Application No: FP/39/25/HH
Site Address: 21 Goodwood Avenue Felpham PO22 8EH
Description of works: Single storey rear extension with steps, front canopy, conversion of loft to habitable use with rear dormer and alterations to fenestration. Single storey front roof extension to facilitate car port and widen driveway entrance with new electric gate and pedestrian access.

Thank you for your internet representation made on 9th May 2025 which has been recorded as an objection with the comments as follows:

Dwg. No. P-003
 Title: Proposed First and Second Floor Plans
 Address: 21 Goodwood Avenue, Felpham, PO22 8EH
 Client: Jonathan and Lauren Penn
 Scale: 1:100@A3
 Stage: PLANNING
 Drawn: PS
 Date: February 2025

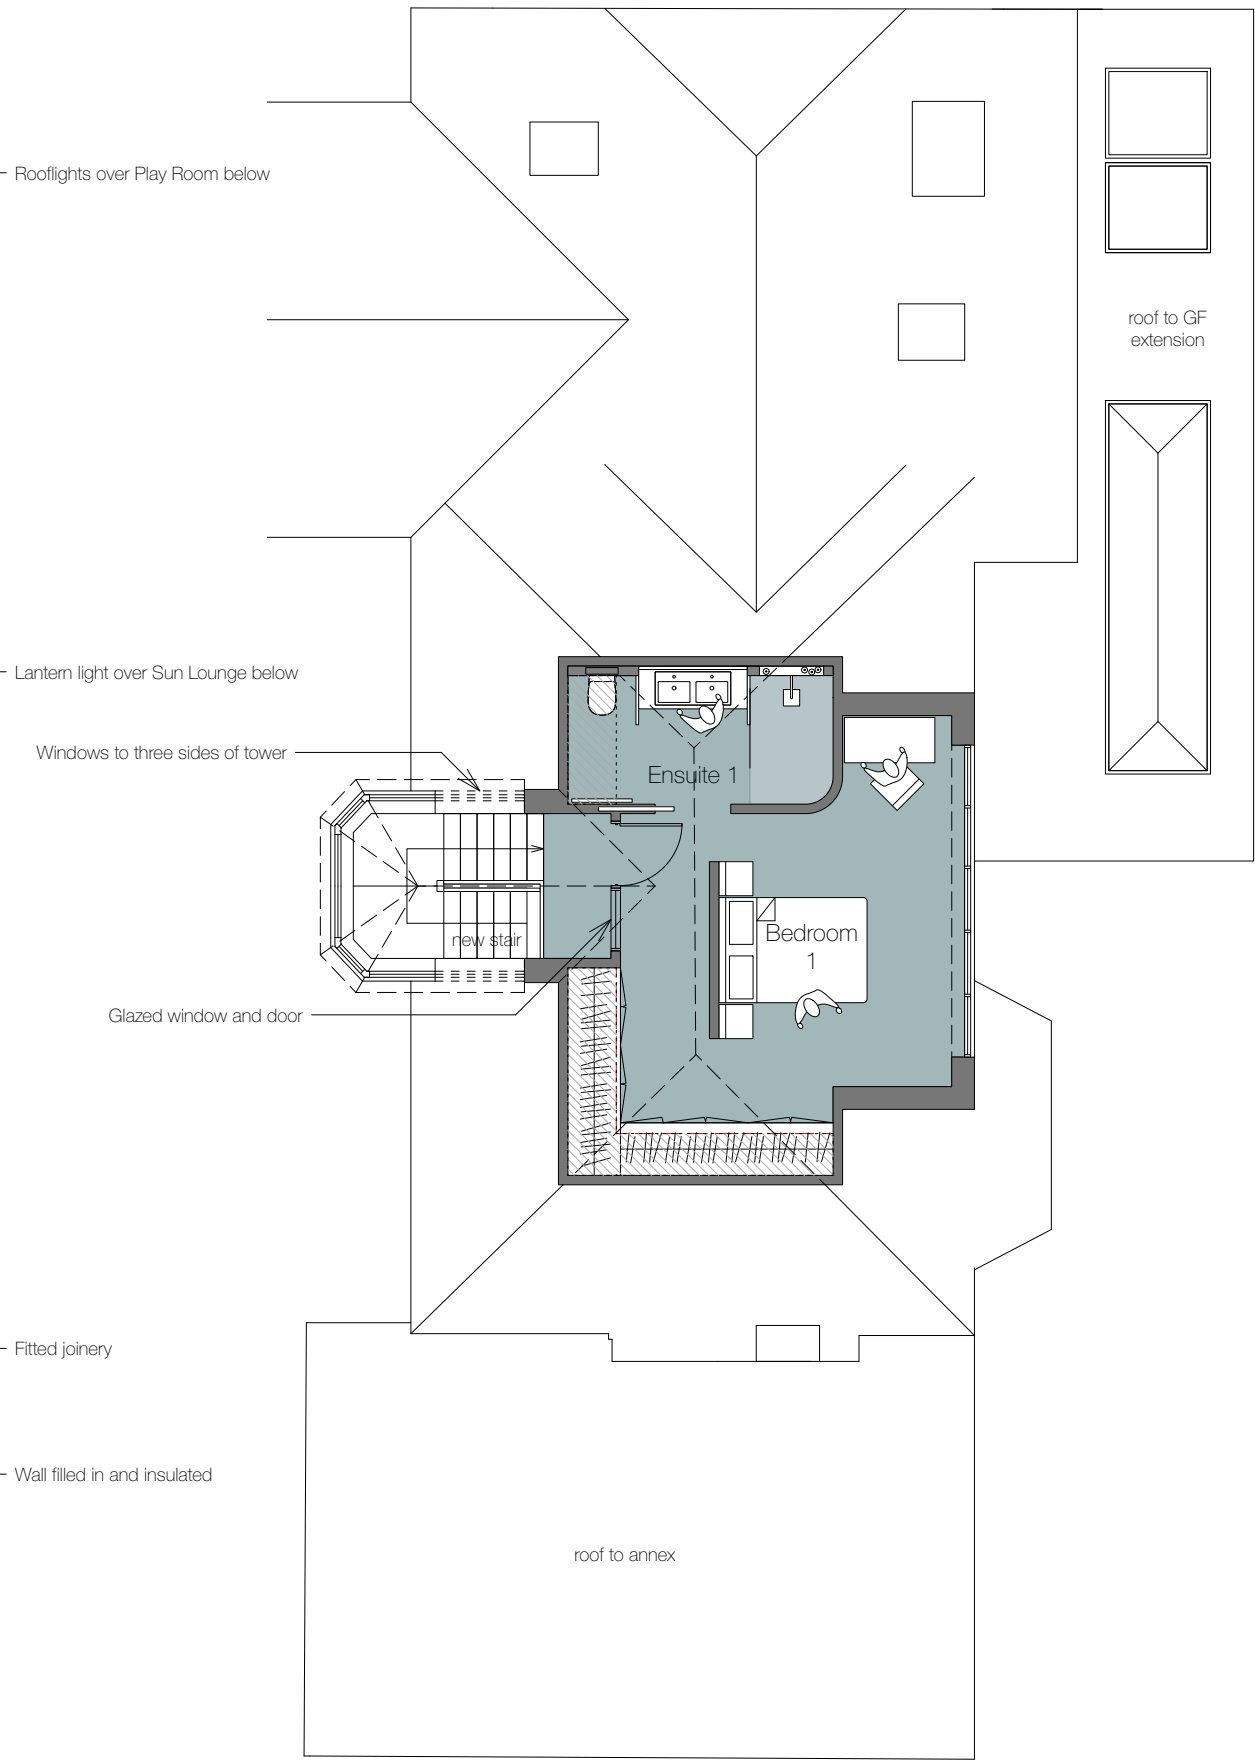
I would like to object to the loft extension part (South Elevation) of this application. The remainder looks very good to me. I object on three grounds.

1. Design. The creation of the 'boxy' room construction is out of keeping with any other properties in the same South visual sweep of South Road and Goodwood Avenue. It is not an appealing design with its huge expanse of glazing.
2. Visual impact. The South roof elevation would be visible to the public from South Road and the Public Footpath alongside the Felpham Community College. It would be further exposed when the trees in a neighbouring property are significantly cut back, as will happen in the next few weeks.
- 3 Loss of Privacy. The wall of glass would look directly into the side window in my property. It will also completely overlook my garden and swimming pool (when the trees are cut back). This will remove garden privacy that has existed for over 30 years.
